ENG-SF22030-R2-CD-redlines.pdf Markup Summary

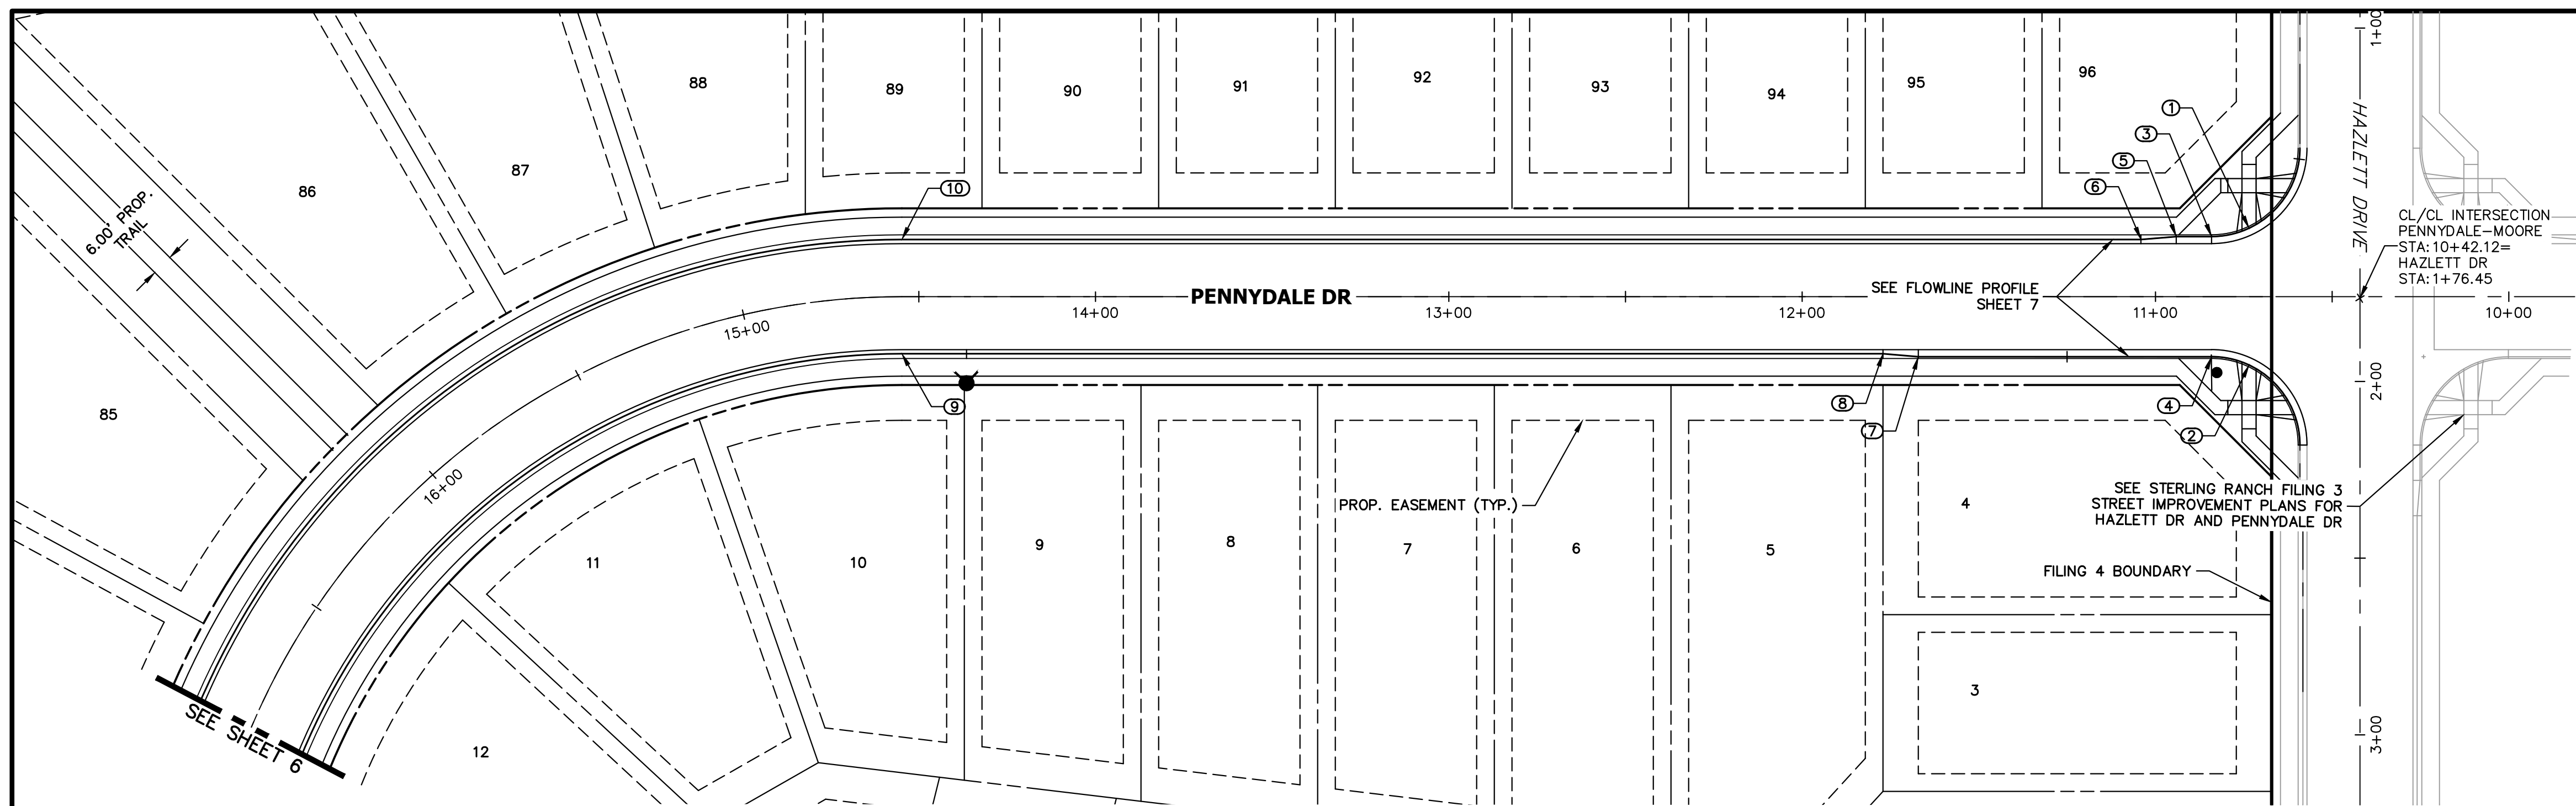
Label lot numbers

PENNYDALE DRIVE
STA 10+40.00 TO 16+50.00
 LOCAL PUBLIC ROAD

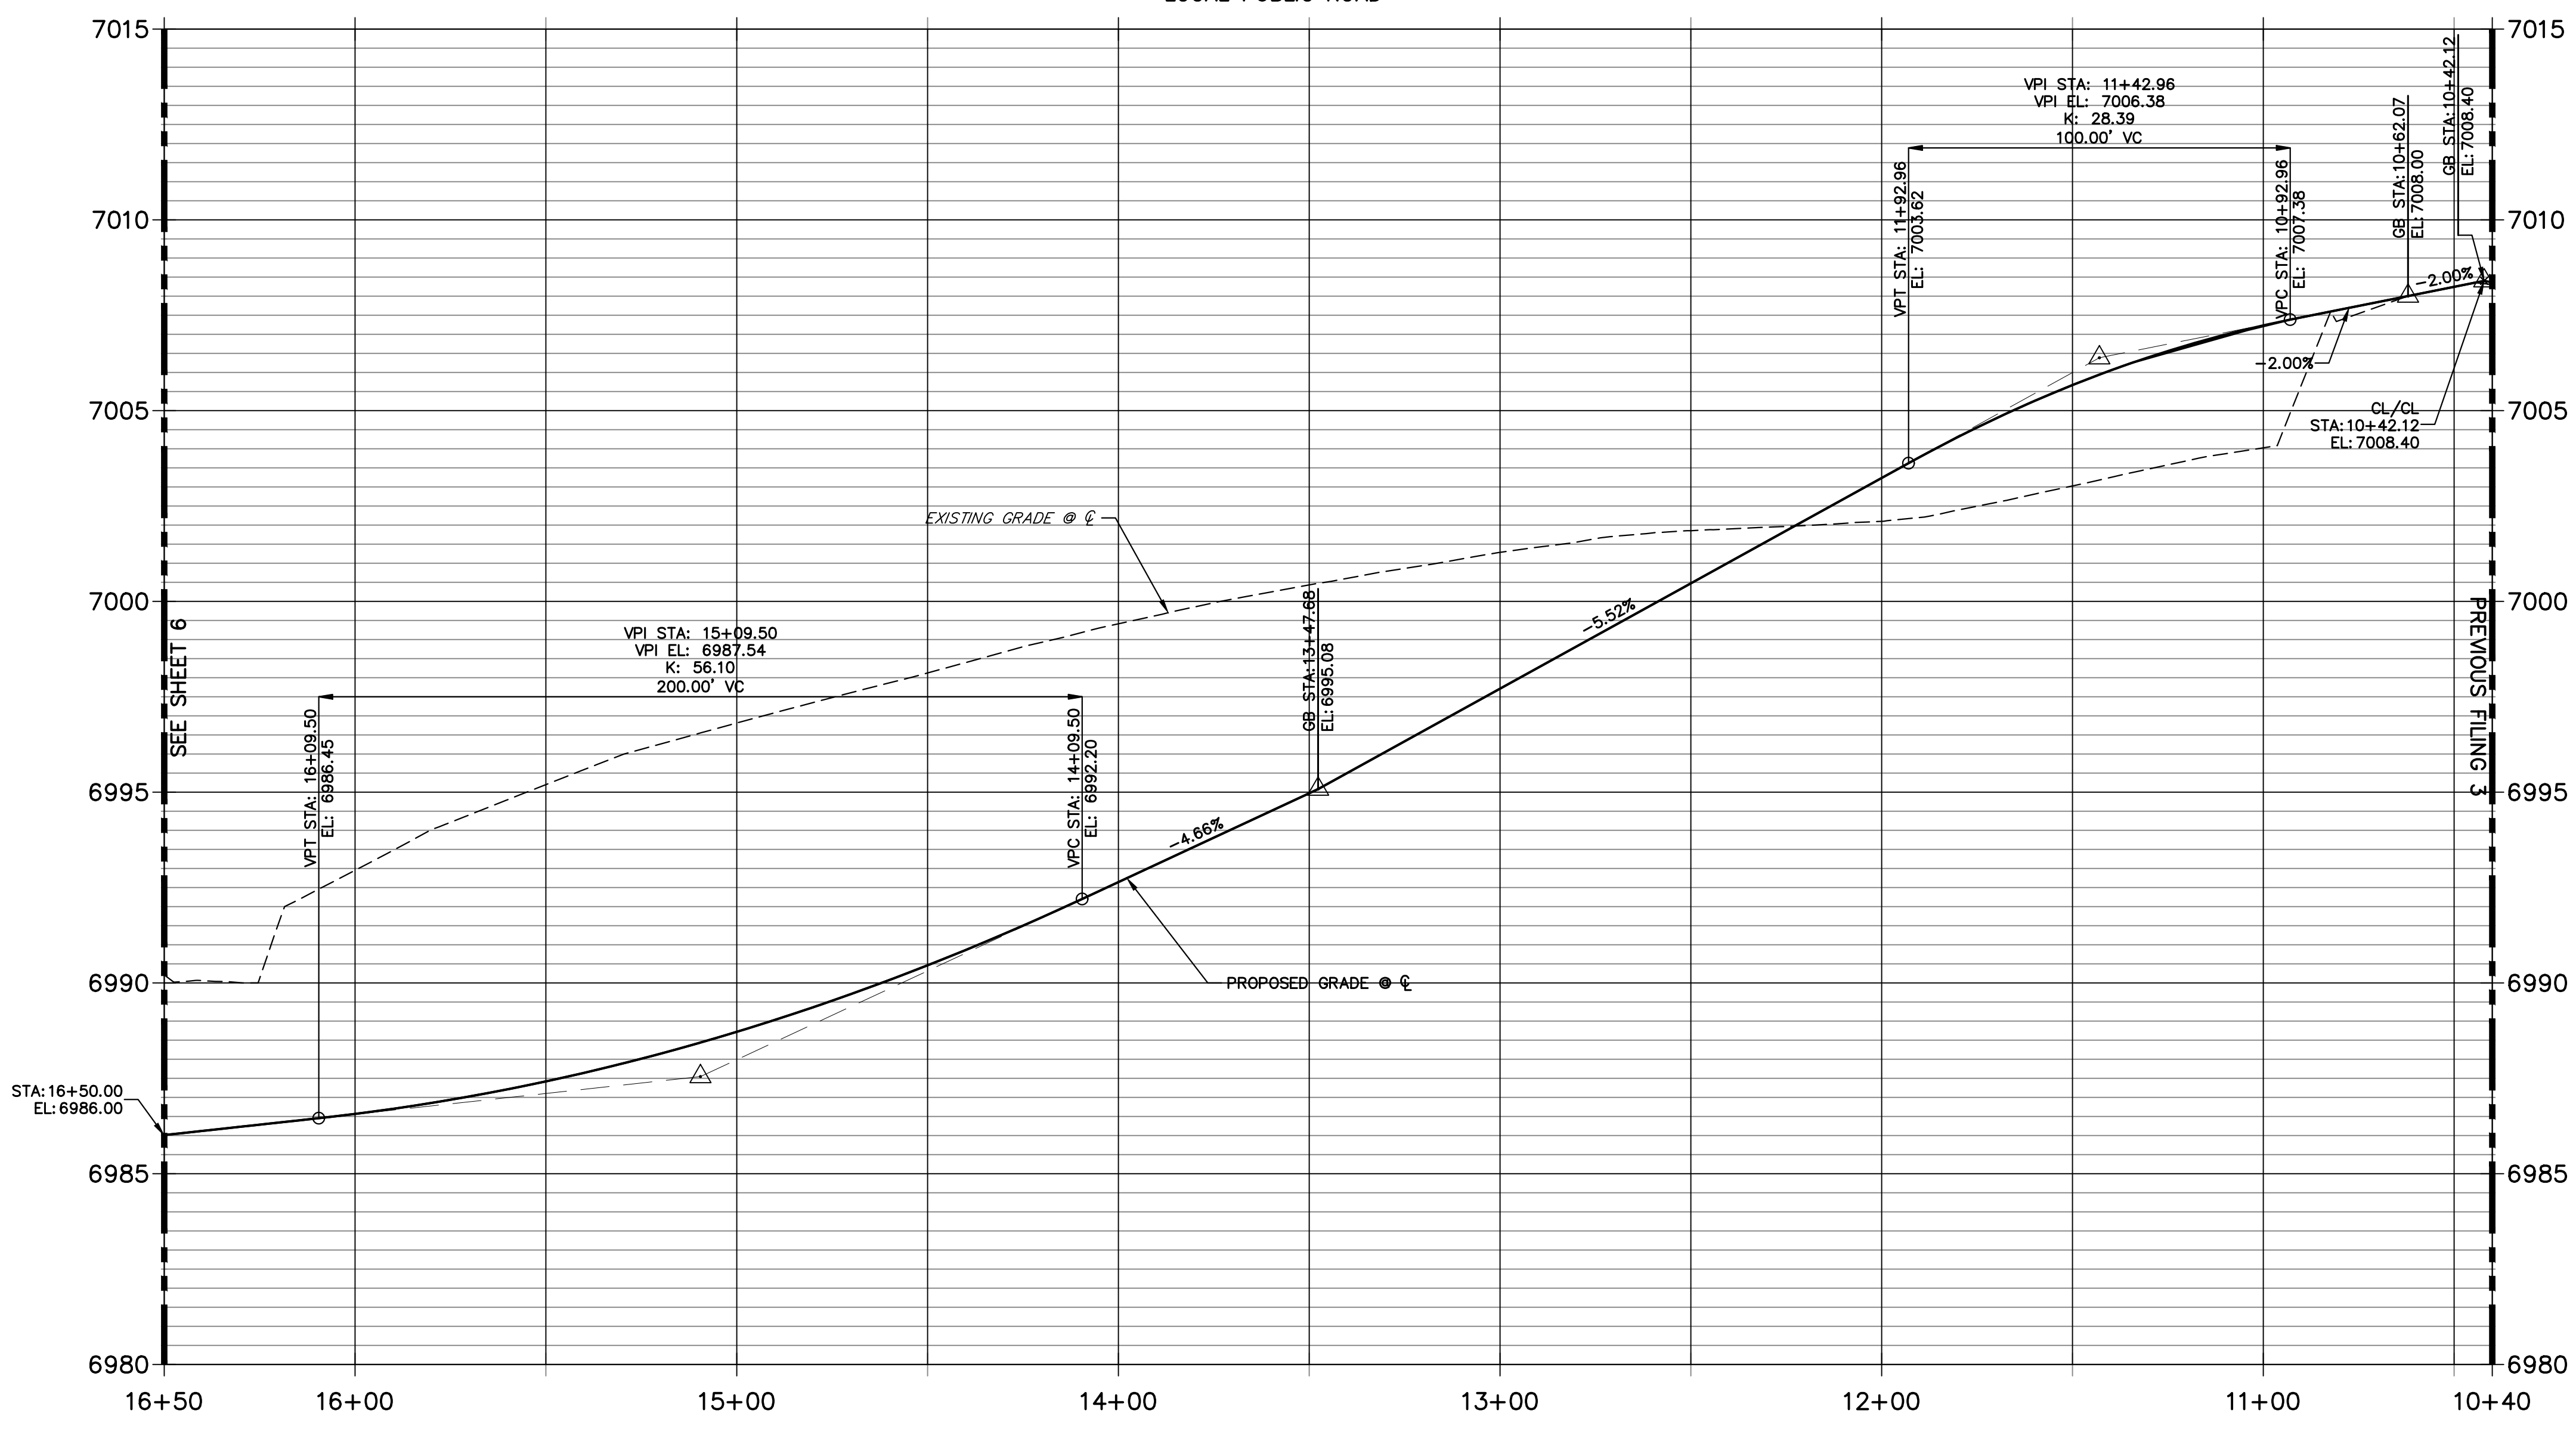
Replace point labels
